From: lucia@studioectypos.com
Sent: Monday, March 23, 2020 1:38 PM
To: Nicole Gaudette
Cc: michele@studioectypos.com
Subject: 74xx SE 38th St. (3623500226)

PAVING AND GRADING PLAN & PROFILE

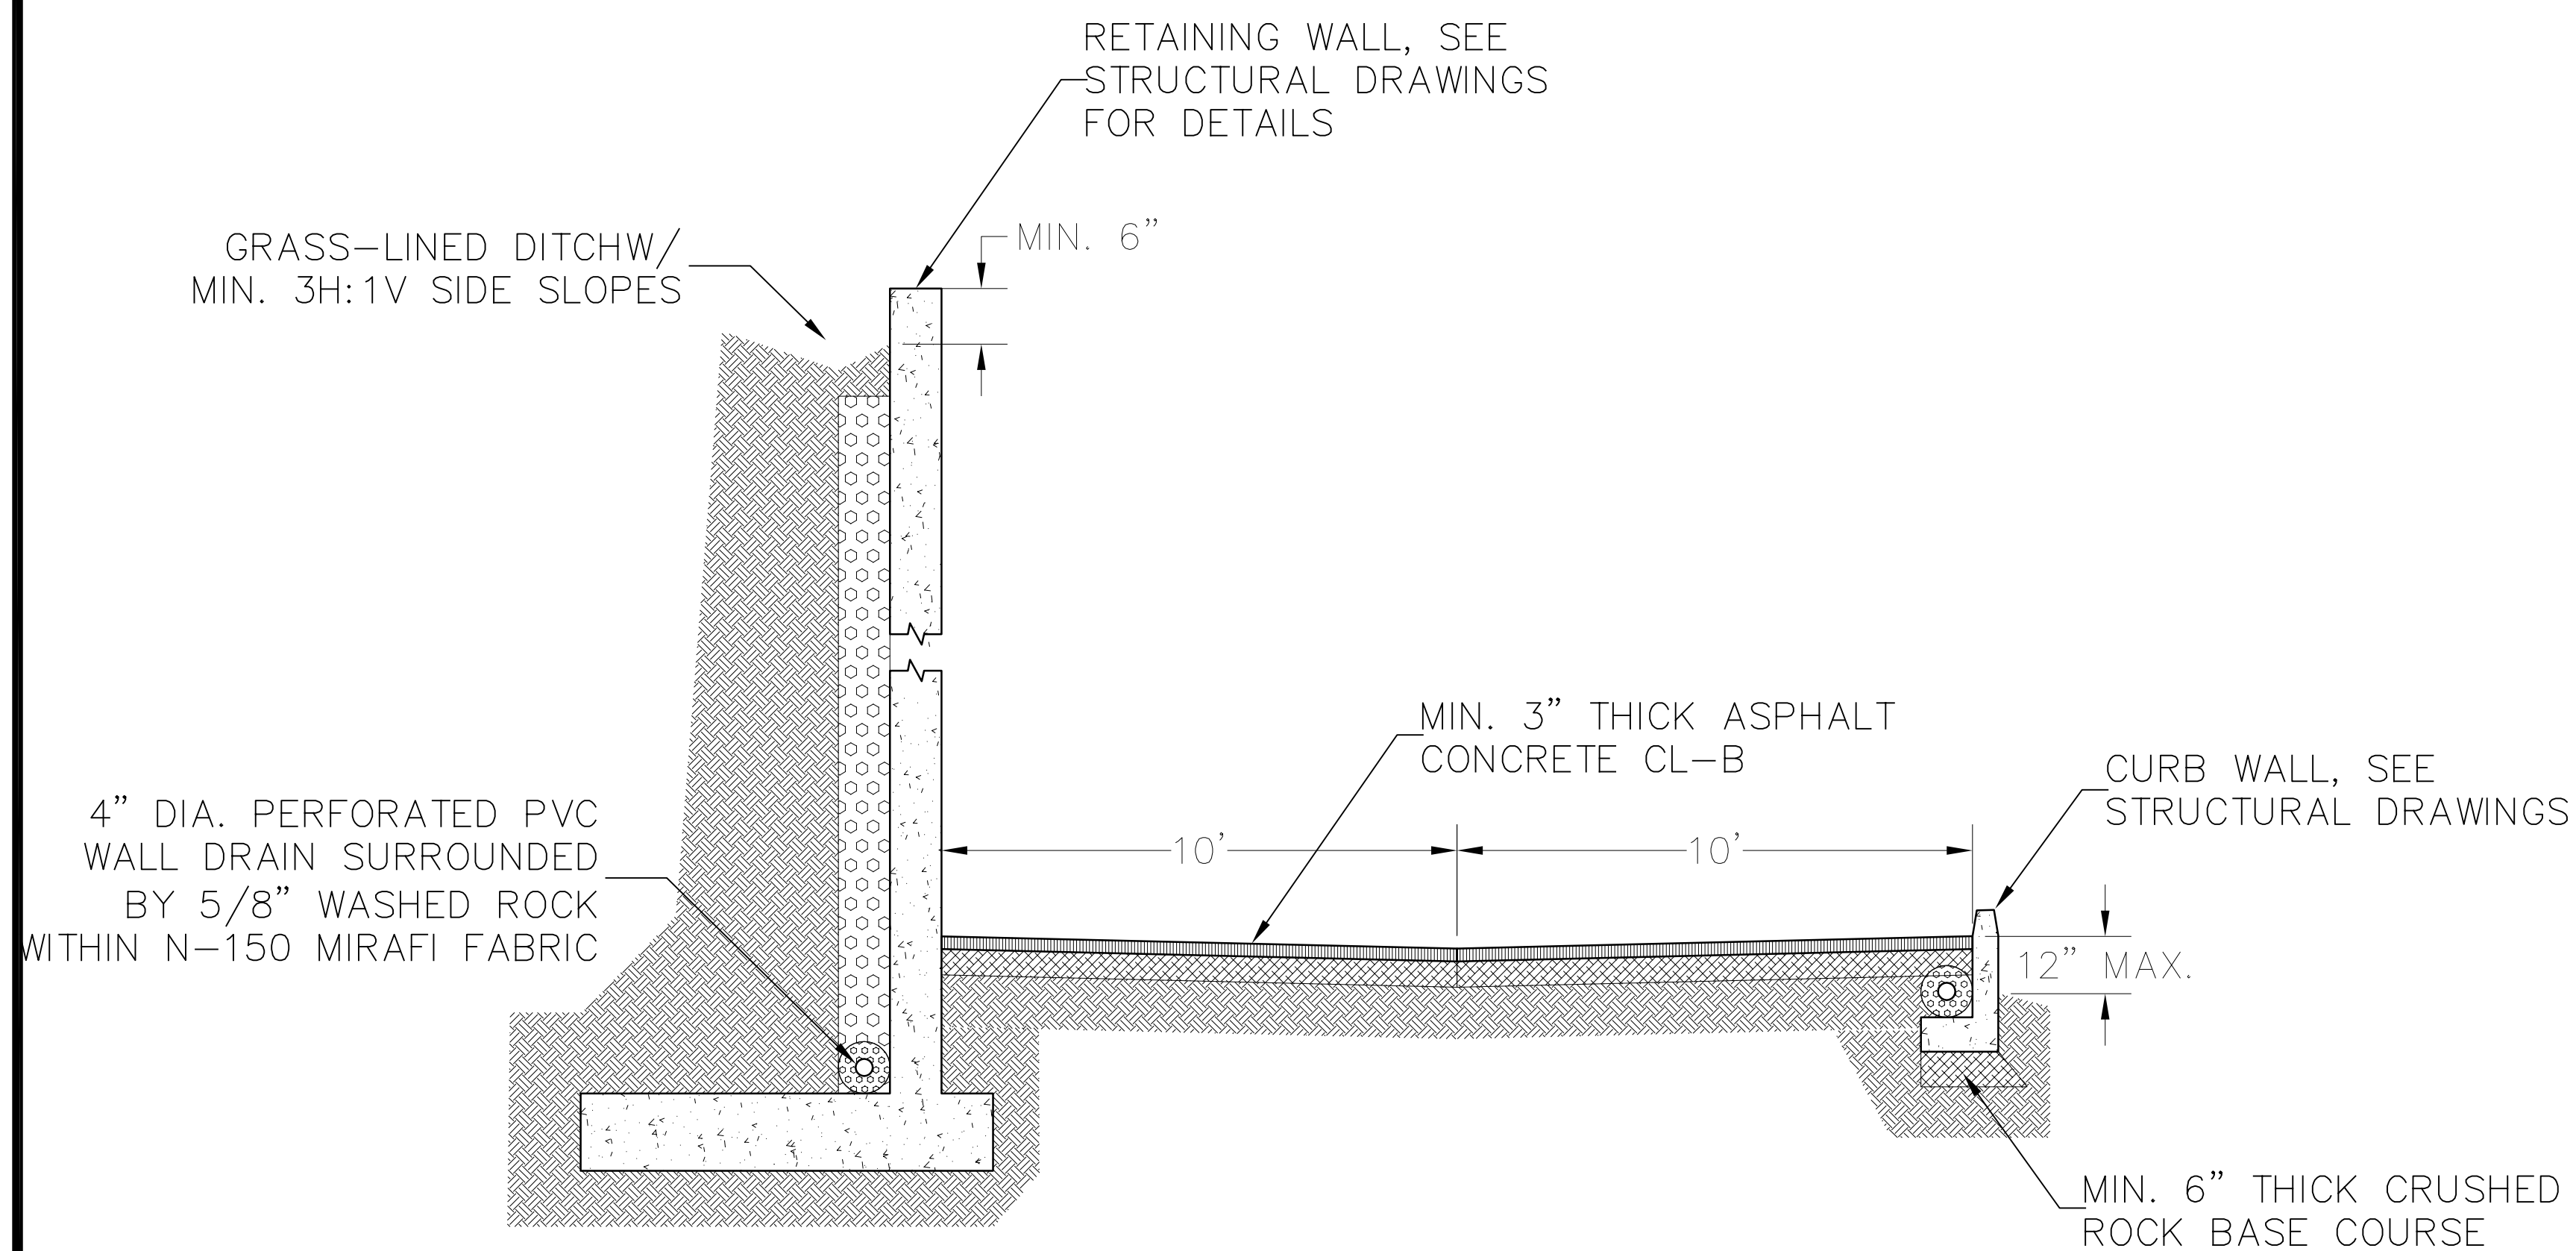
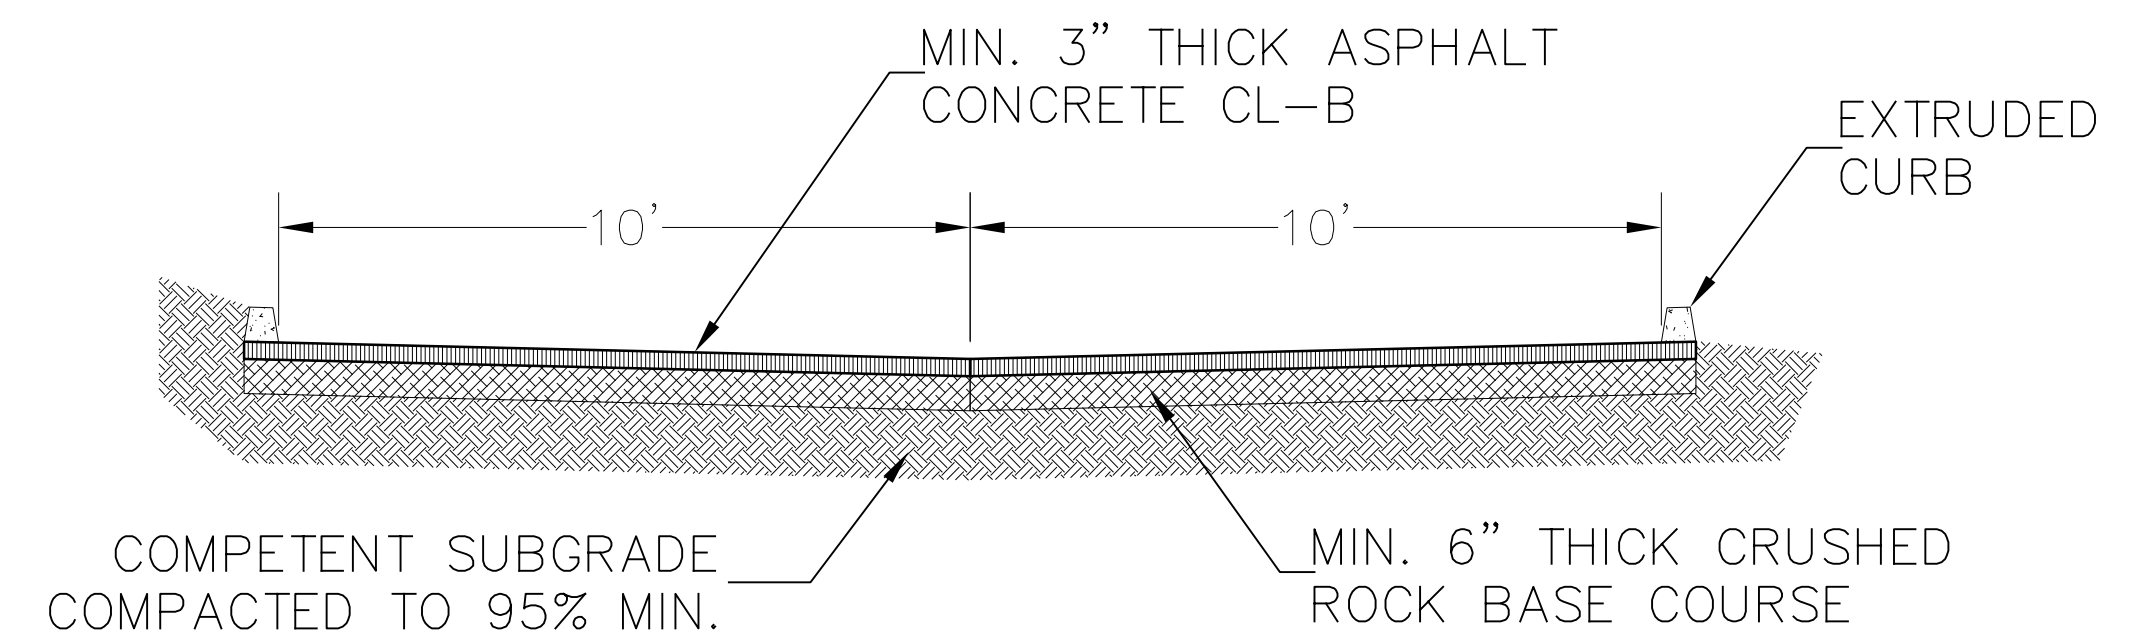
The application is a critical areas determination and they have only submitted drawings for construction of the access road that looks to be about 30' wide with an 8-10' high retaining wall which seems herculean for a driveway. What is the minimum width for a driveway?
